RE: Carroll Short Plat (SP-07-137)

The Kittitas County Community Development Services Department has determined that the Carroll Short Plat (SP-07-137) is a complete application and hereby grants *conditional preliminary approval* subject to the following conditions:

TO: Trudie Pettit, Staff Planner, Community Development Services
FROM: Randy Carbary, Planner II *rc*
DATE: September 18, 2007
SUBJECT: Carroll Short Plat

CARROLL SHORT PLAT
PART OF SECTION 18,
T. 17 N., R. 20 E., W.M.
KITTITAS COUNTY, WA

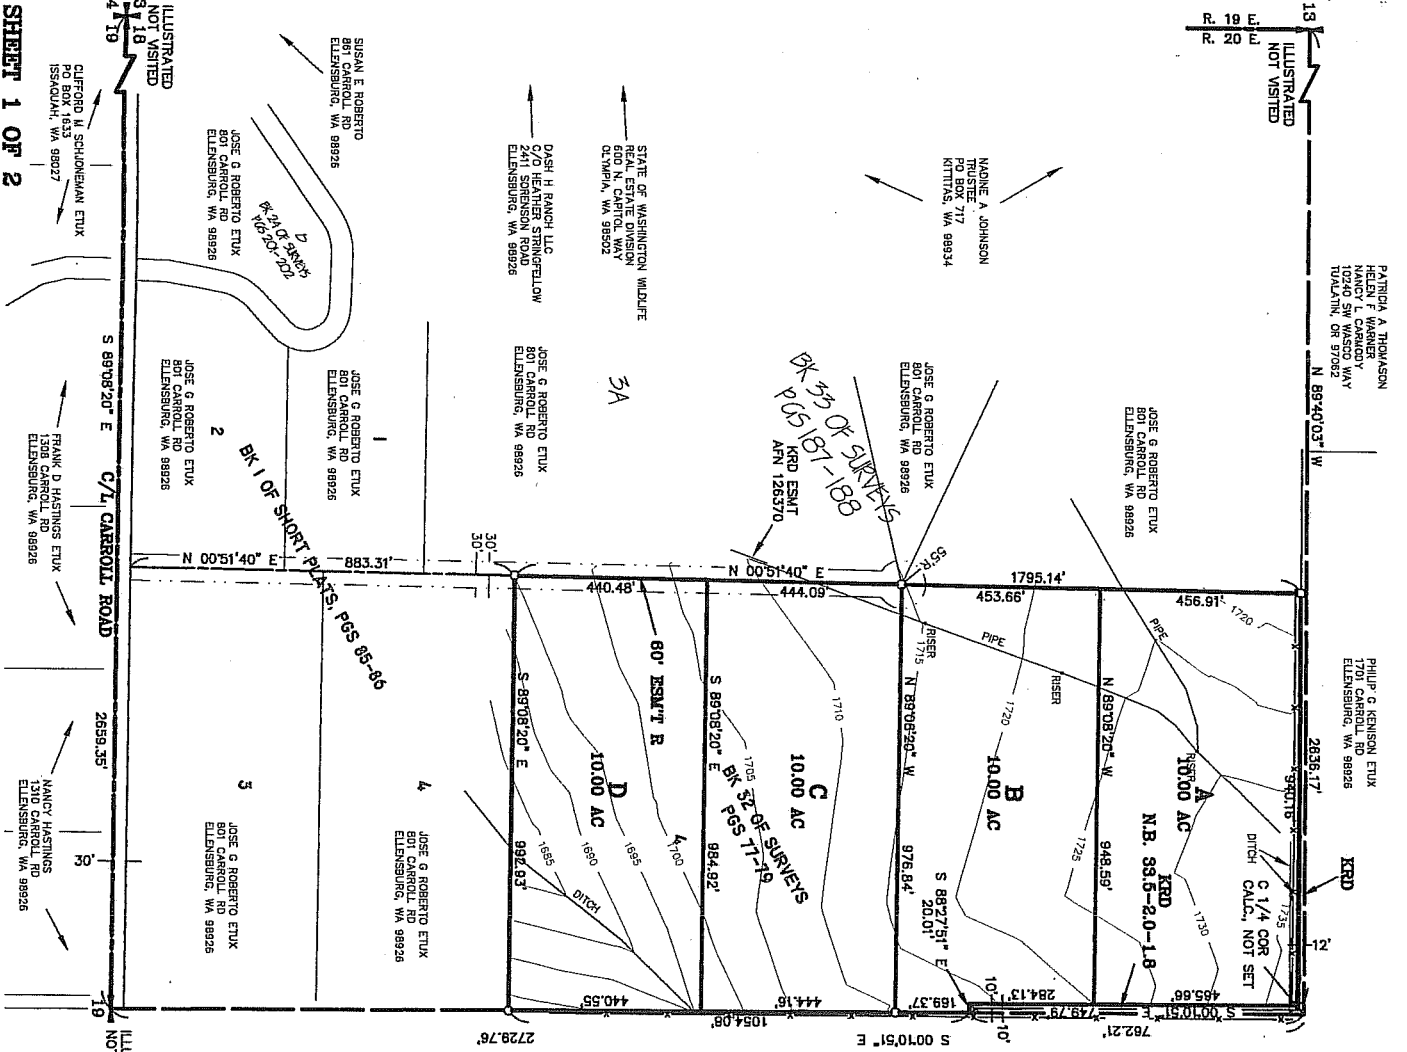
1. Both sheets of the final mylars shall reflect short plat number SP-07-137 and an accurate legal description shall be shown on the face of the final plat.

2. Correct map numbers of 17-20-18000-0021 and 17-20-18000-0016 shall be on the face of the plat.
3. Full year's taxes must be paid for 2007 on all tax parcel numbers per requirement of the Kittitas County Treasurer's Office.

- a. Cul-de-sac design, reference AASHTO.
 - b. Contact the Fire Marshall regarding any additional cul-de-sac requirements.
4. Access to Lot A: There does not appear to be an access easement proposed for lot A. It is assumed that lot A's access will originate from the cul-de-sac, as shown on the face of the plat. Access to lot A shall be via a 20' wide access easement and shall meet or exceed current Kittitas County Road Standards for a joint-use access shall serve no more than two tax parcels. See Kittitas County Road Standards, 9/6/05 edition.
